**Oakdale West Estate-Mod-6 (SSD-7348-Mod-6)  
Request for Additional Information**

I refer to the proposed modification application for the Oakdale West Estate (SSD-7348-Mod-6). The Department is requesting that you provide additional information, as outlined below.

LOT 1B & 1C, KEMPS CREEK, OAKDALE WEST ESTATE

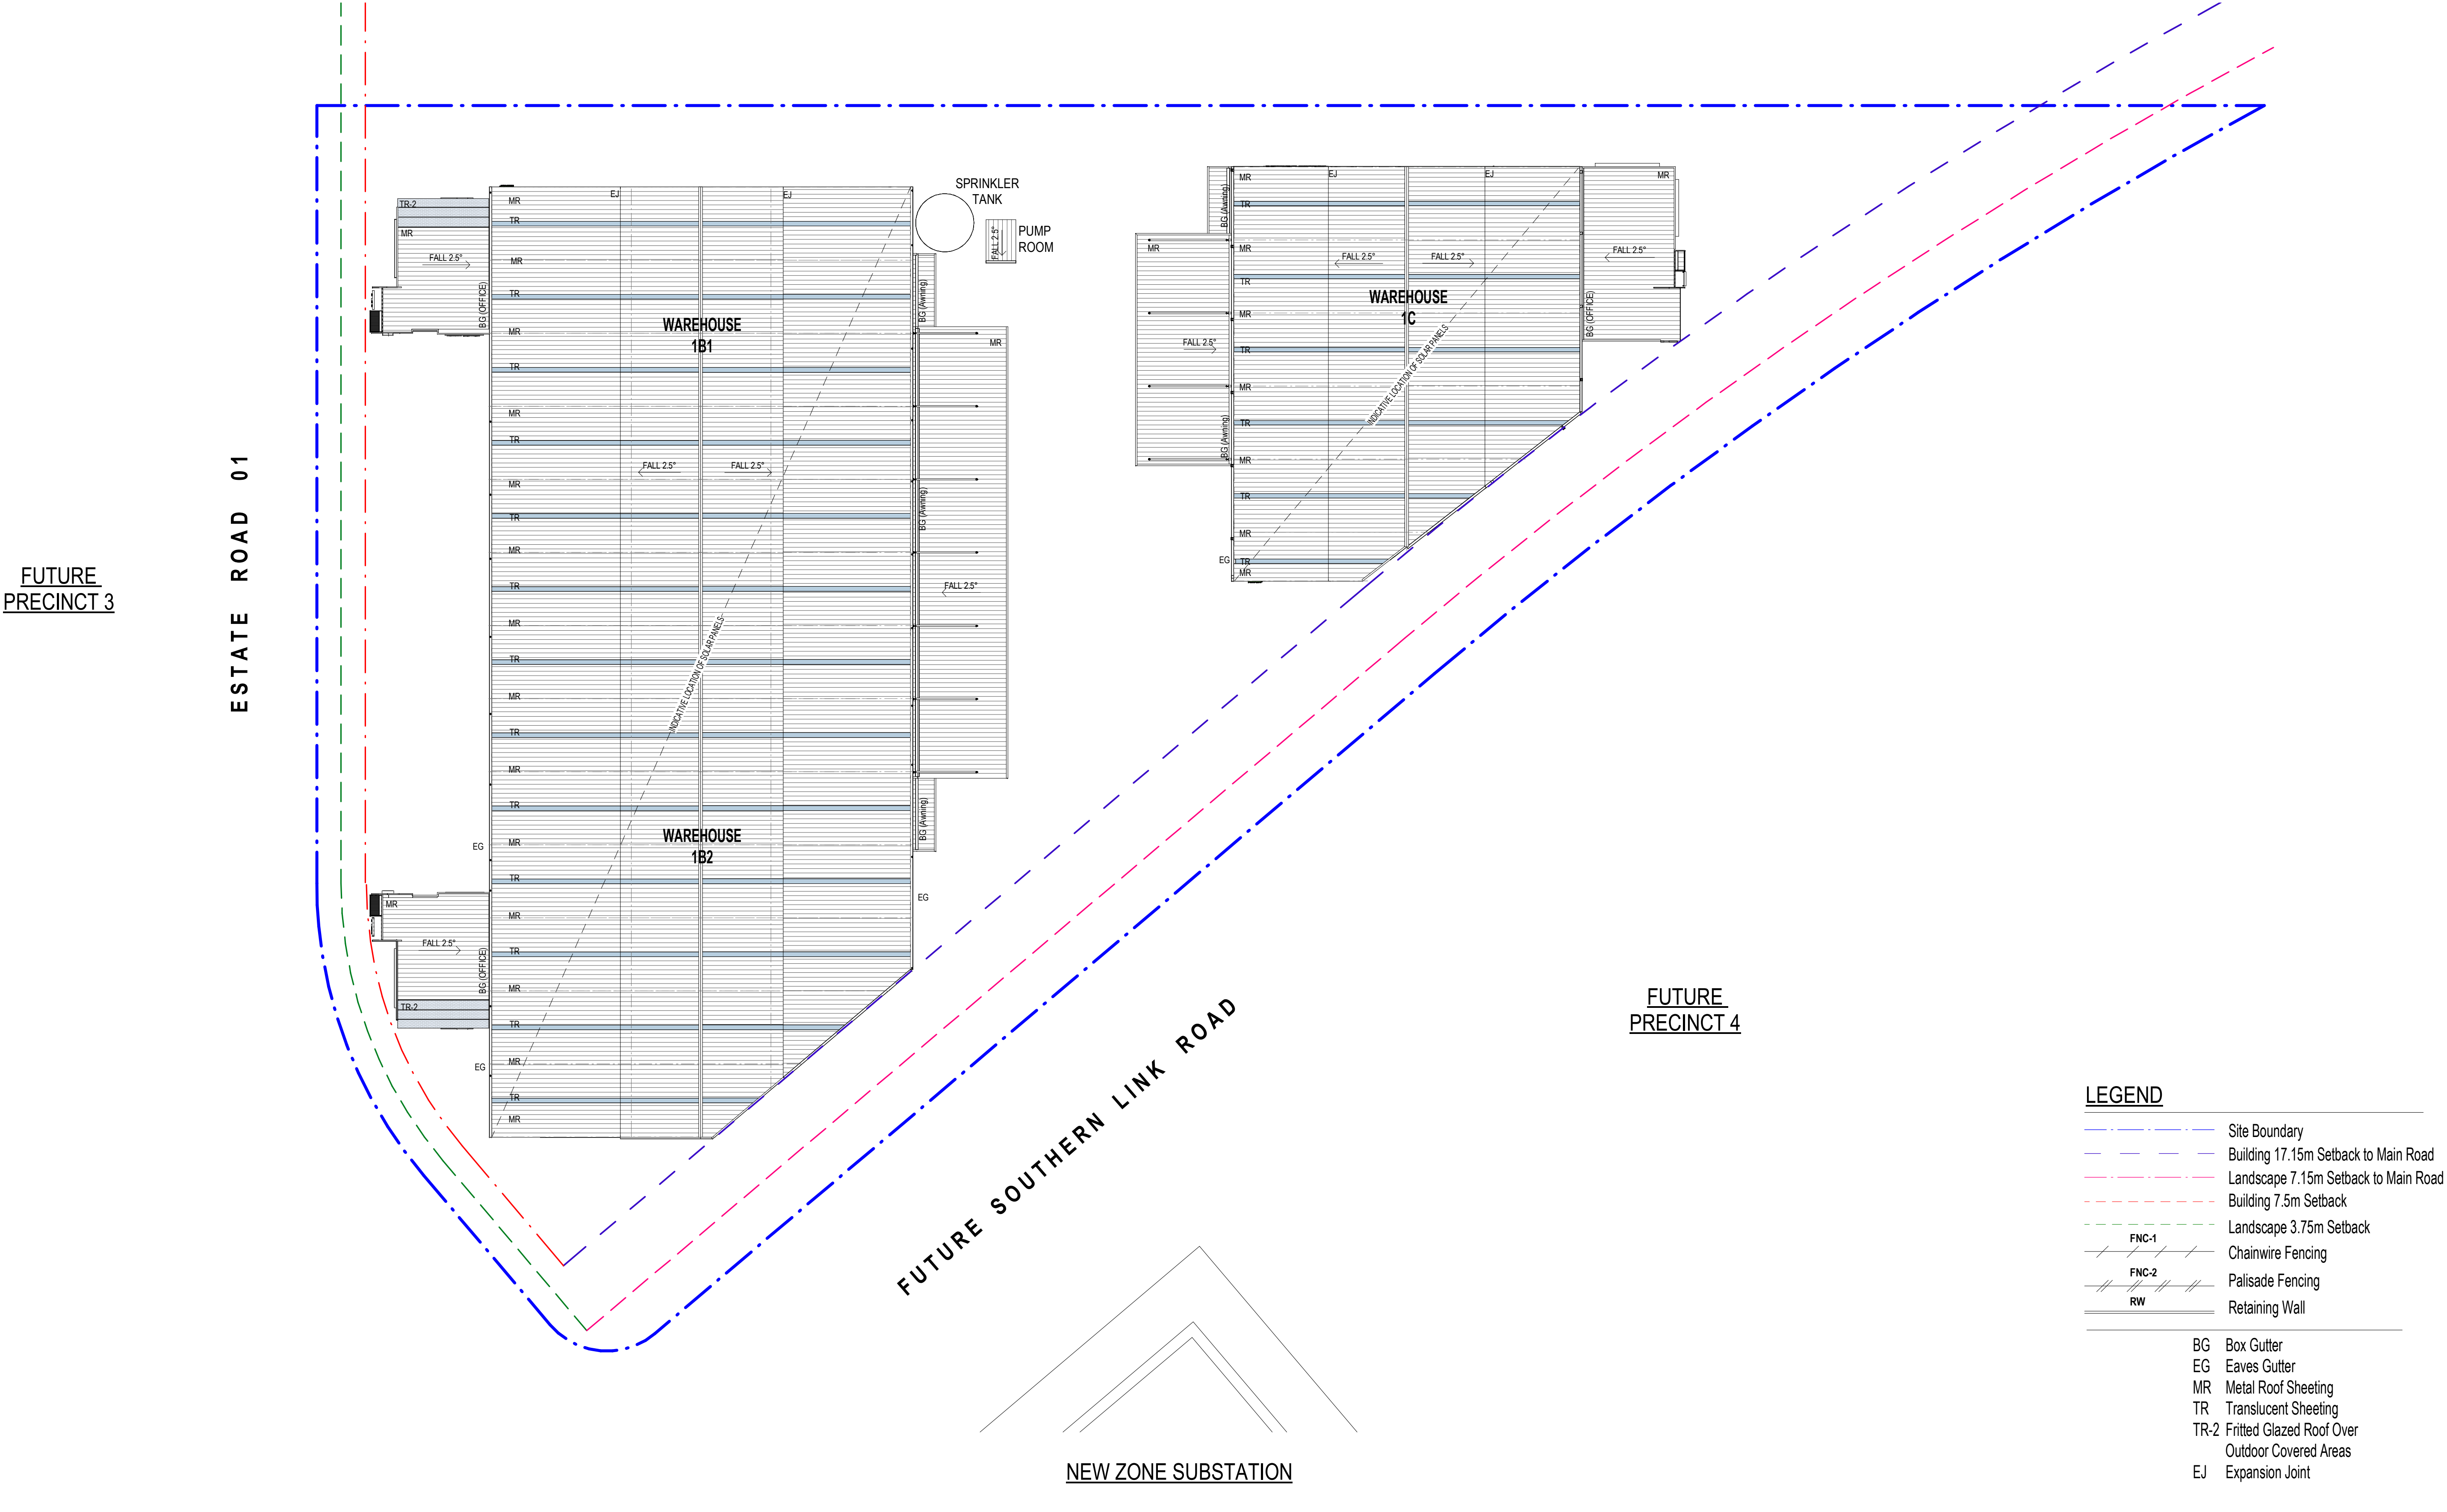
- It is noted that the proposed areas and car parking spaces identified in Table 3 of the Modification Report do not match with the figures shown on the site plan for Buildings 1B and 1C (OAK-DA-DA30 E). Please ensure the figures are in agreement between the report and plans, and that adequate parking spaces are provided in accordance with any changes in GFA and the relevant parking rate.
- The Department has received the attached advice from TransGrid, which appears to have already been sent to AT&L. Please confirm whether the advice has been reviewed by Goodman/AT&L and whether any changes to the modification are required. It is noted that further information/clarification is requested under Point 3 of the letter.
